**Re: Innova Plaza South Building,
401 Eubank Blvd. SE Albuquerque, NM
Request for Certificate of Occupancy
Transportation Development Final Inspection**
Engineer's/Architect's Stamp dated 03-03-2017 (L20D067)
Certification dated 02-12-2018

Based upon the information provided in your submittal received 11-21-2018, Transportation Development will issue a 30-day Temporary Certificate of Occupancy based solely on the Traffic Certification dated 02-12-2018. This letter serves as a "green tag" from Transportation Development for a 30-day Temporary Certificate of Occupancy to be issued by the Building and Safety Division.

INNOVA PLAZA - SITE DEVELOPMENT
OVERALL SITE PLAN
401 EUBANK SE, ALBUQUERQUE, NM 87123
PROJECT #1459

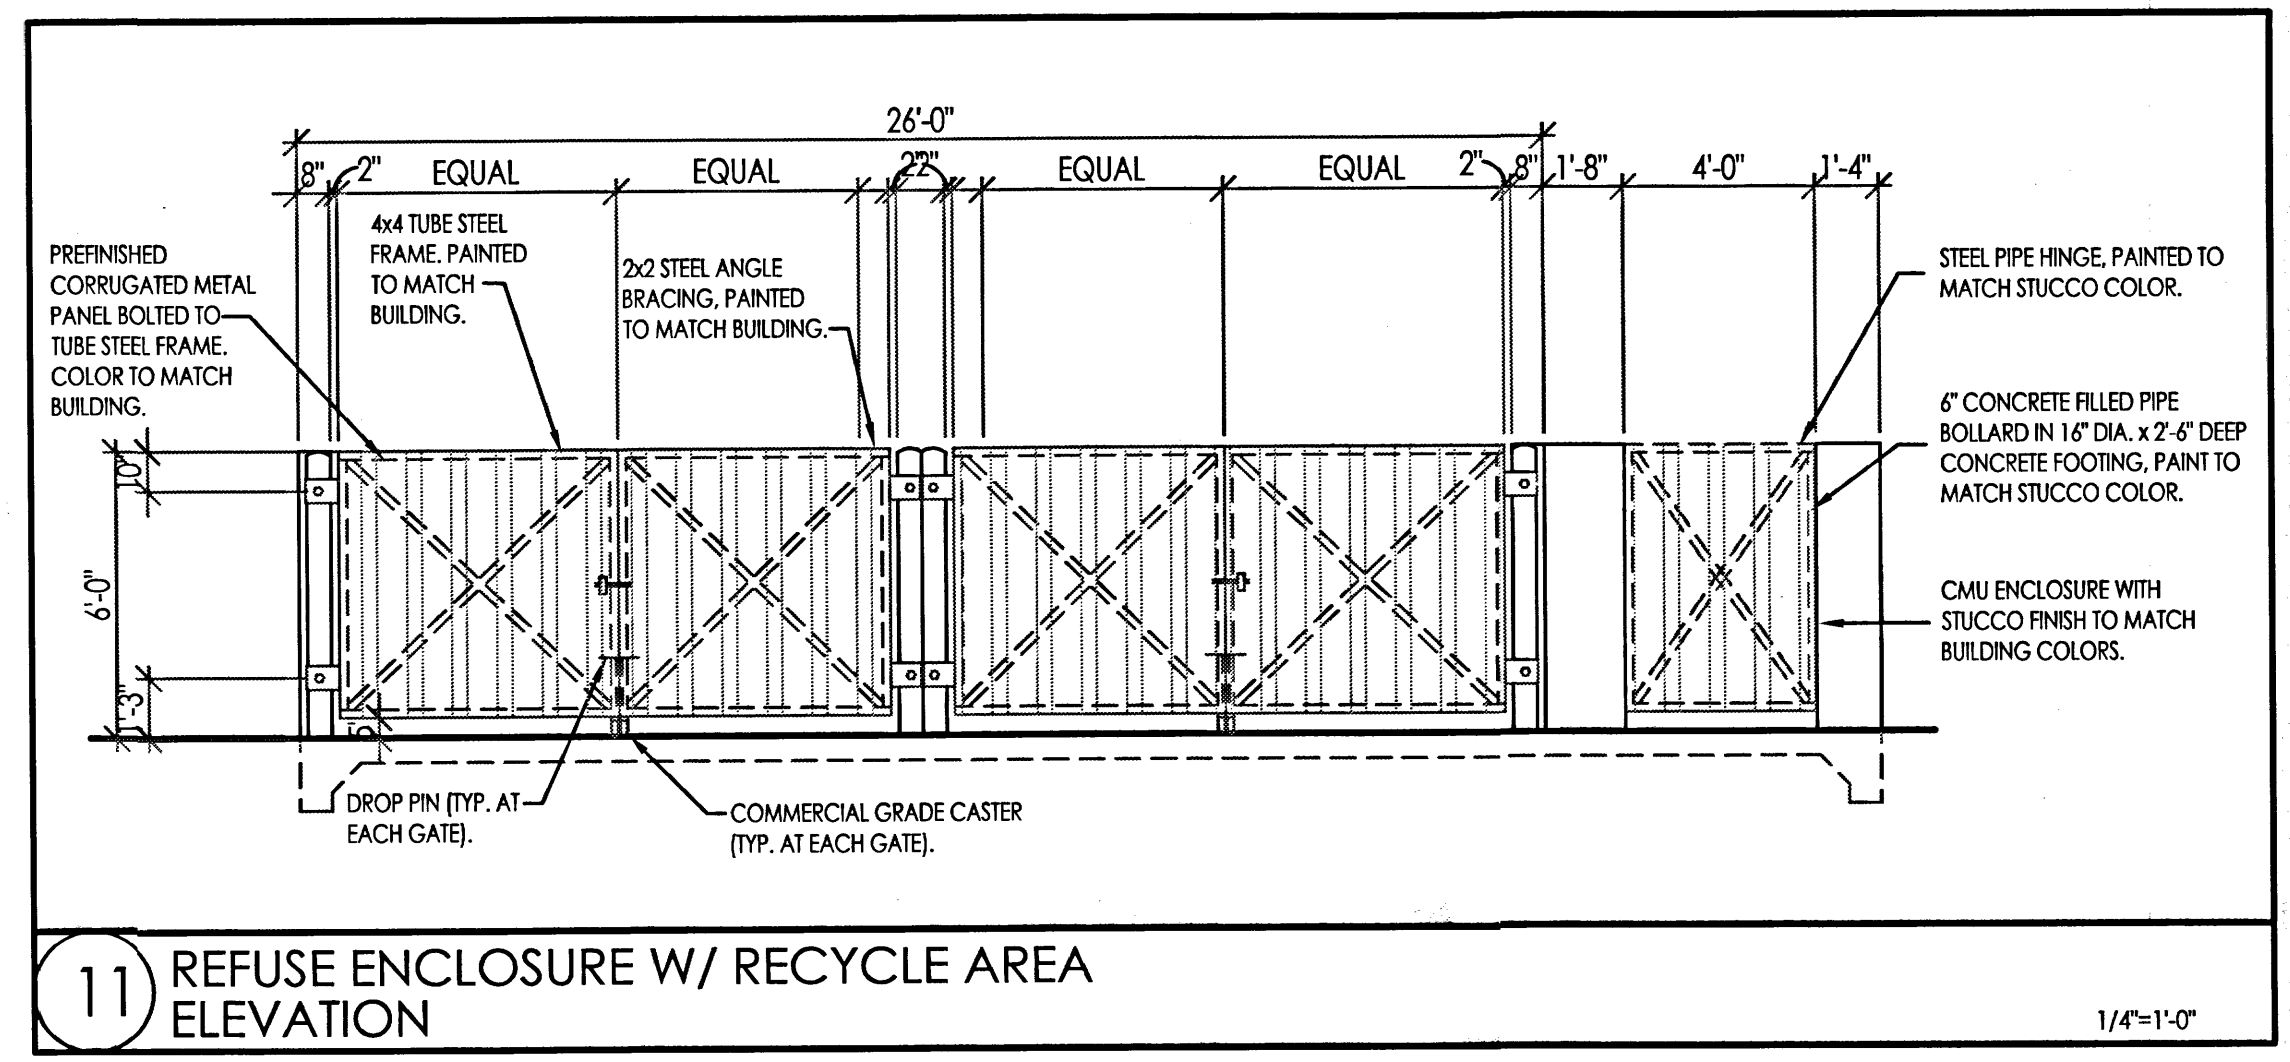
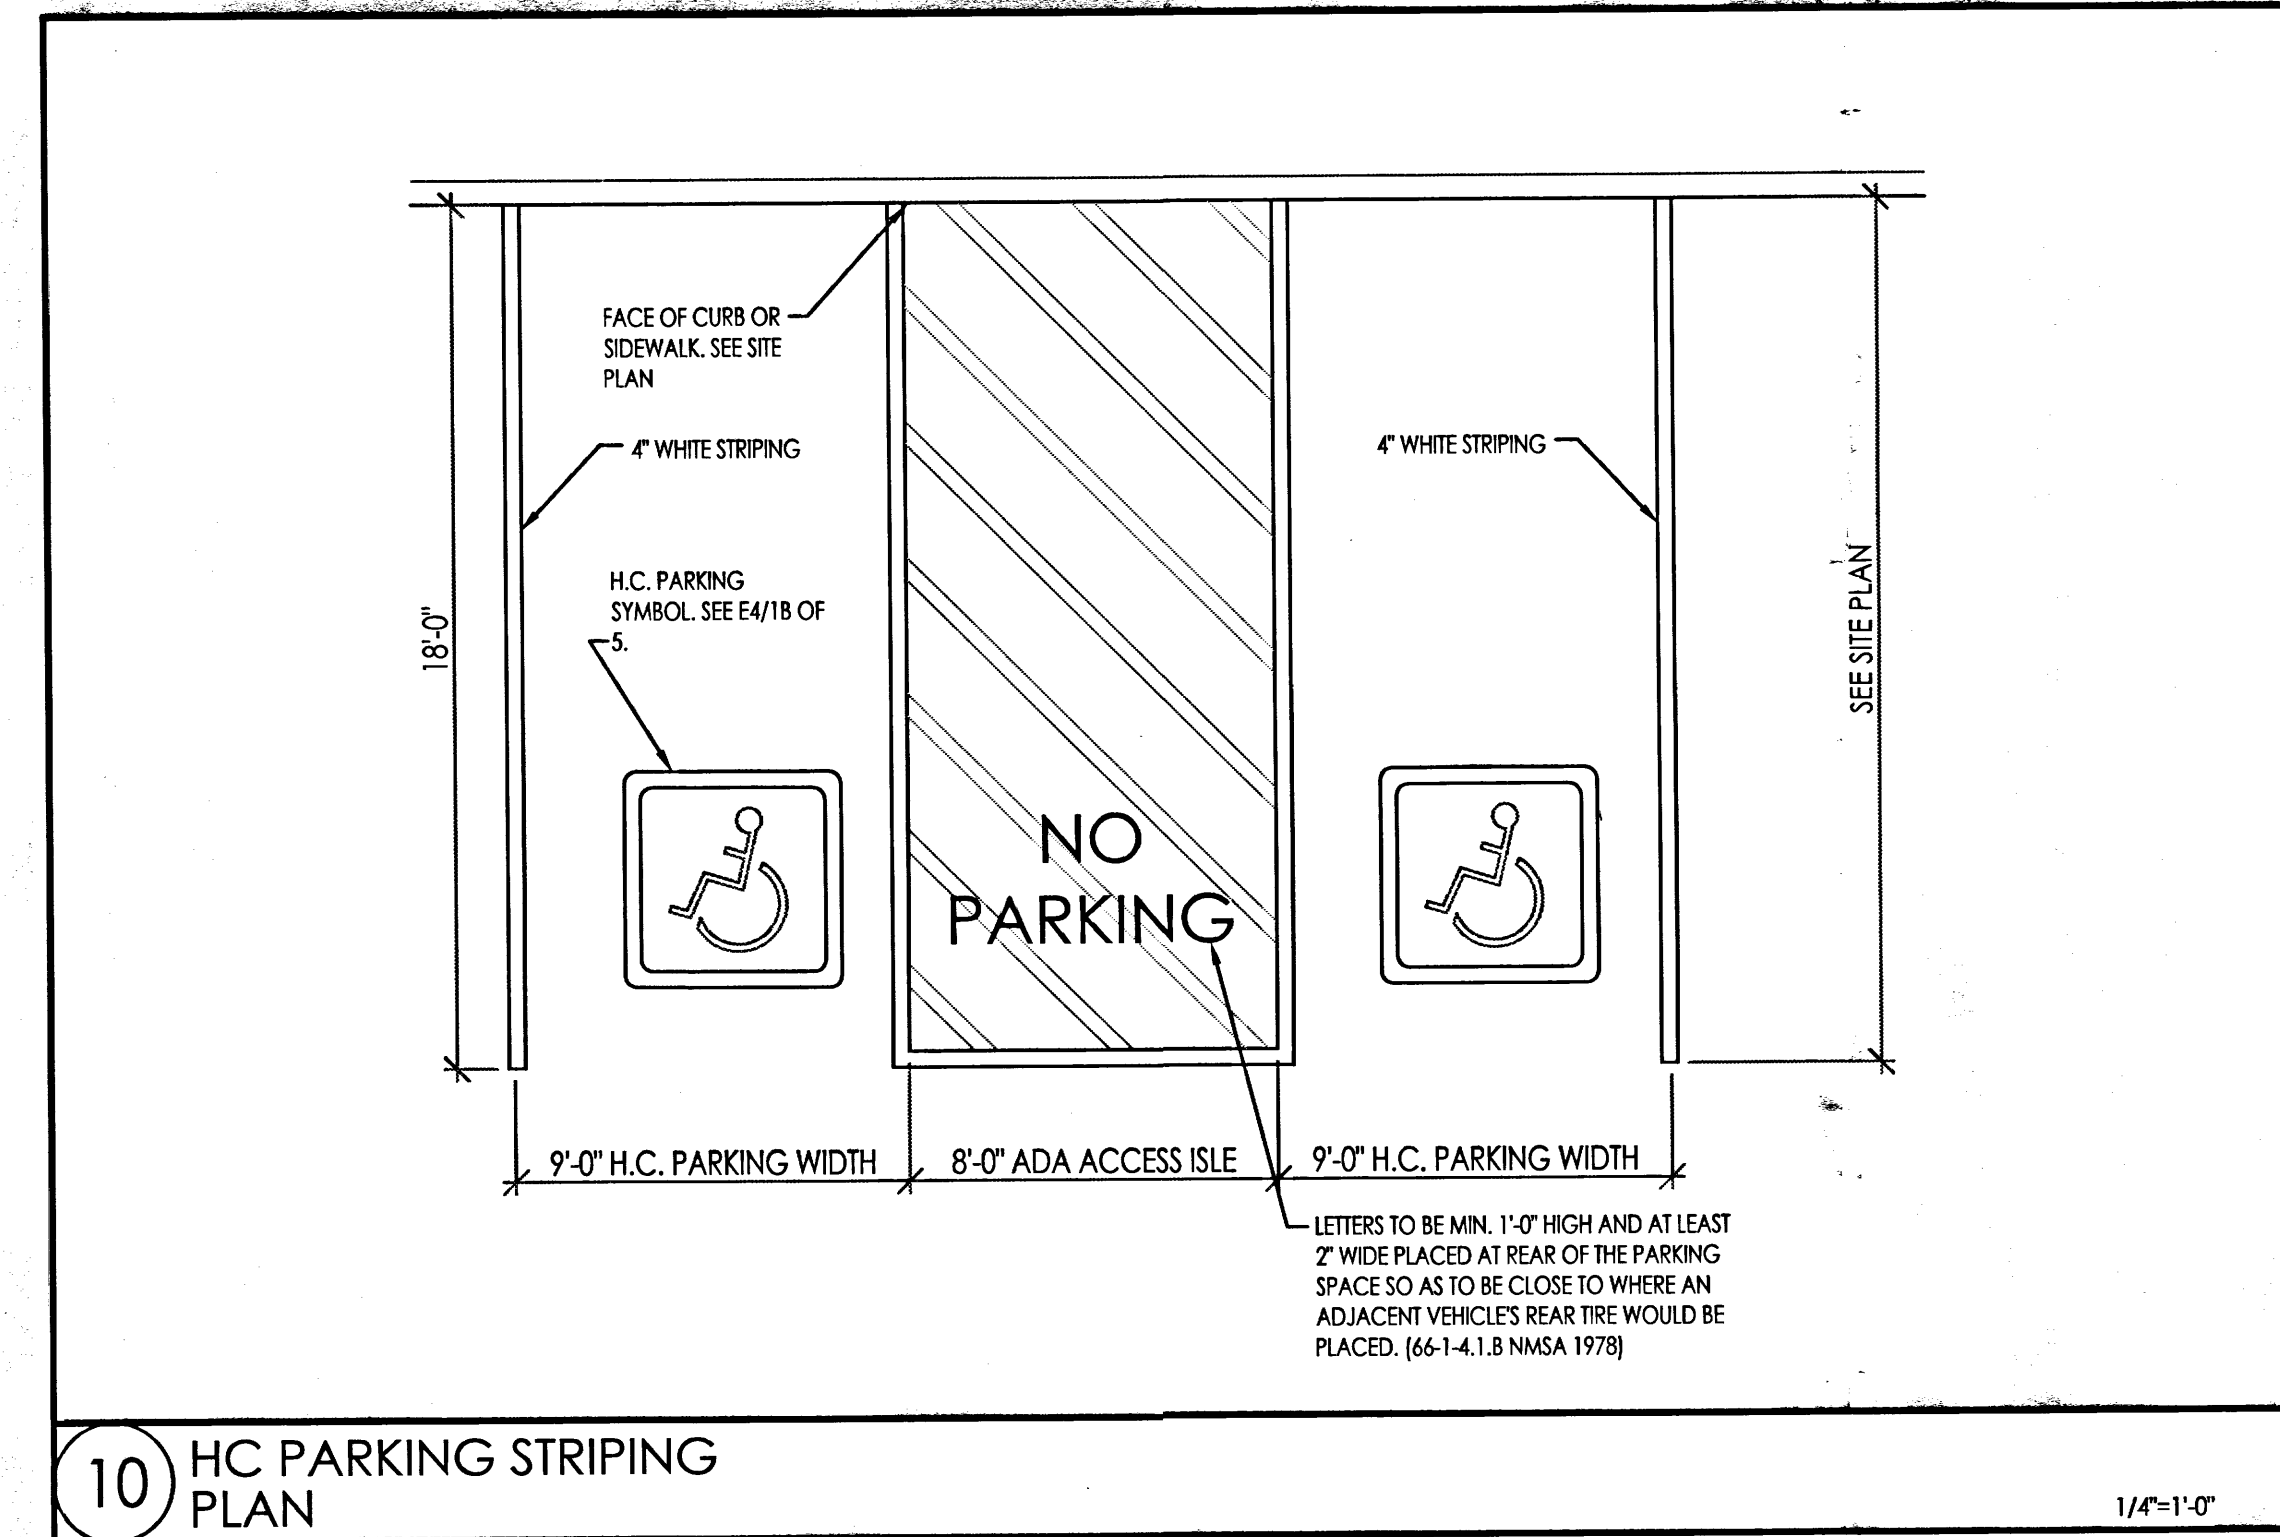
- Please clear the site of all the debris
- Please install a pedestrian access connecting the side walk to the building the same way it was approved in the original submittal on 03-14-2018.
- Please make sure all the striping are the same as the original submittals.
